From: Ian Johnson [REDACTED]
Sent: 29 October 2019 15:22
To: Simon Davis <Simon.Davis@arun.gov.uk>; Martyn White <Martyn.White@arun.gov.uk>
Cc: Lucy Hill [REDACTED]
Subject: RE: Reserve Matters Application: Bonhams Field, Yapton (ADC ref. Y/63/19/RES)

Thank you again for meeting with Lucy and me on Friday to discuss the above. We thought it may be helpful to provide you with a note of the main actions agreed at the meeting. We have also updated the Parish Council with a note of the actions listed below.

PROJECT	Bonham's Field, Yapton	
DRAWING	Plots 16,17 & 18 Proposed Plans & Elevations	
	P113	A

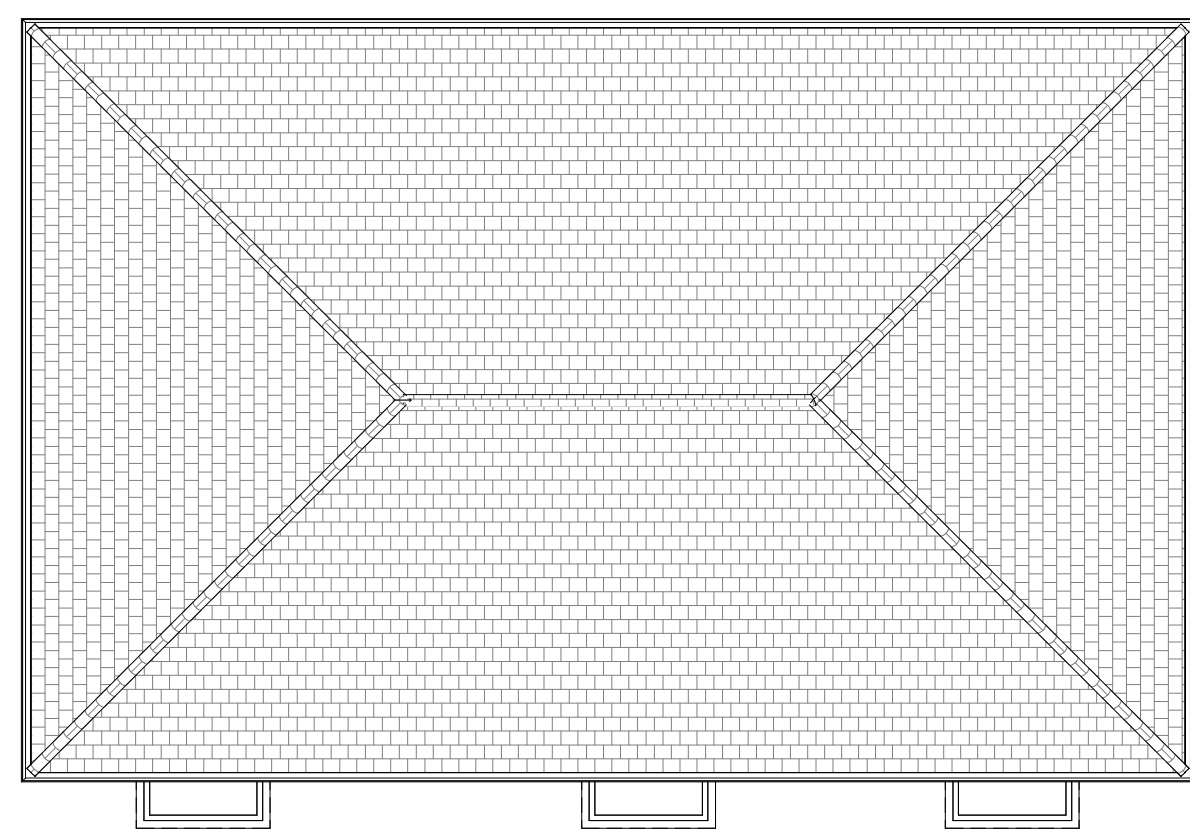
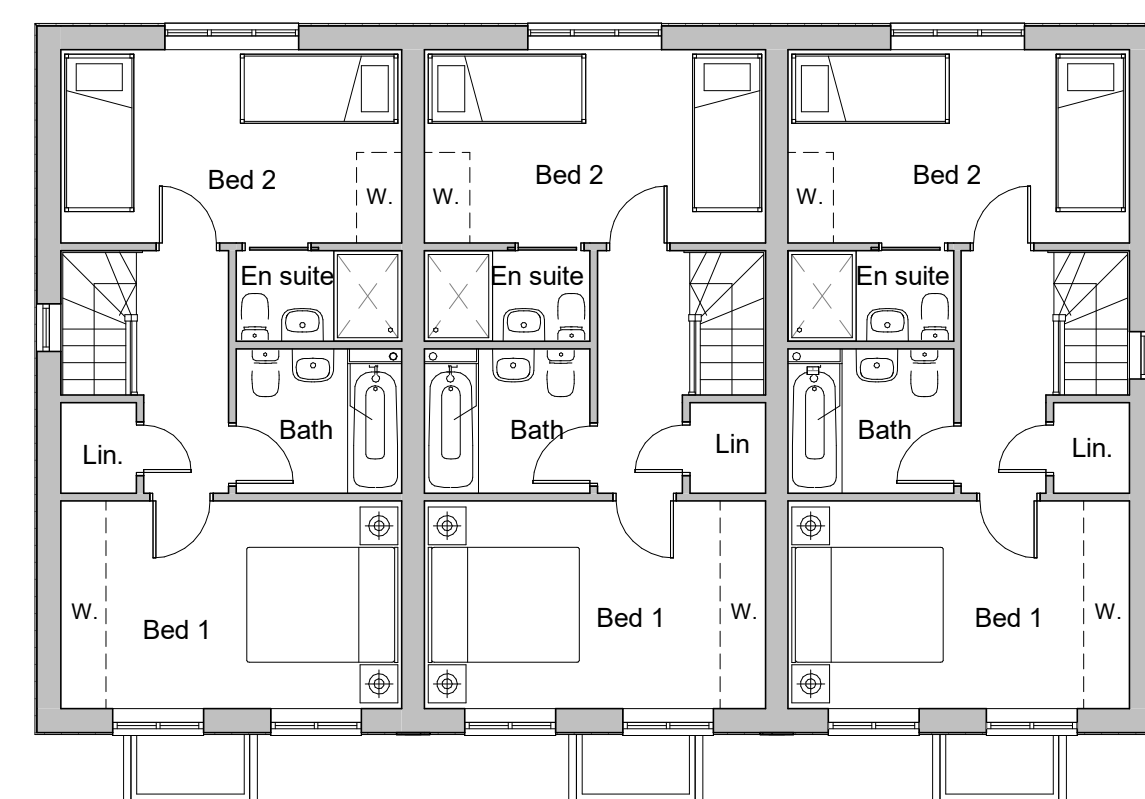
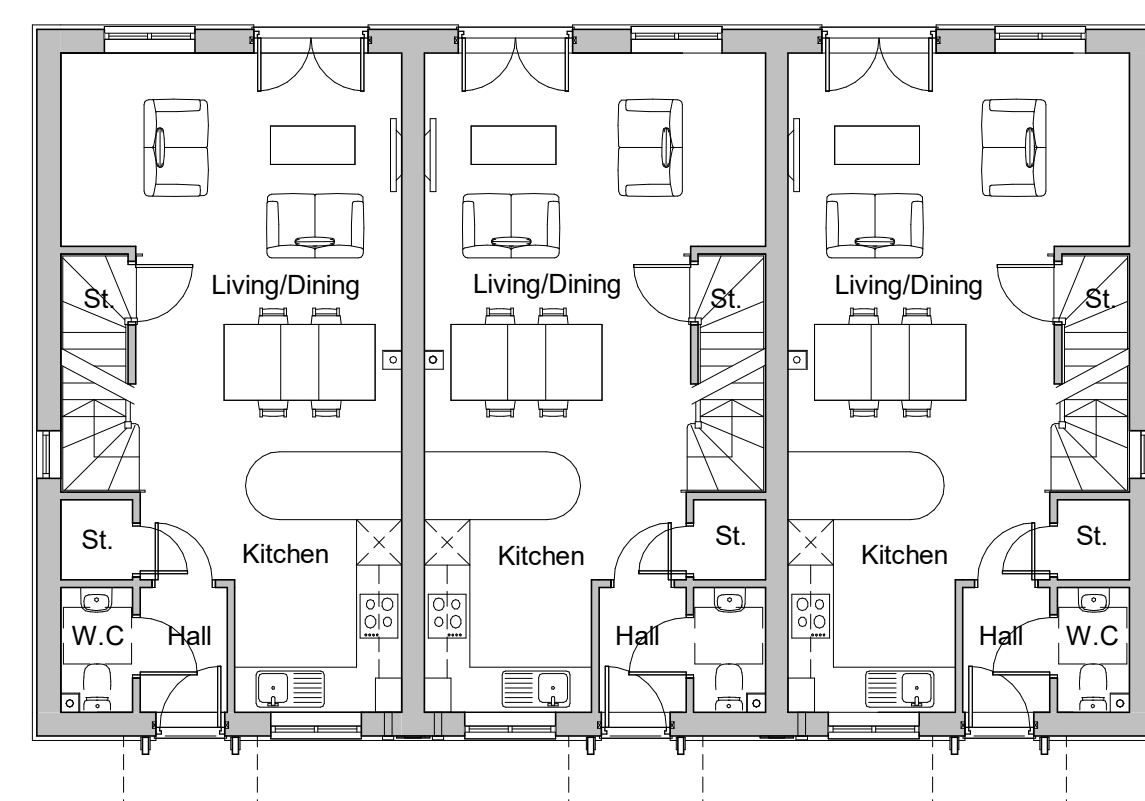
5. Replacement of flat roof porches to Plots 16 – 18 with apex roof / heavy timber porches.
6. No change to the single storey barn style dwellings closest to the Conservation Area (or provision of strip of POS along the back of the rear gardens).
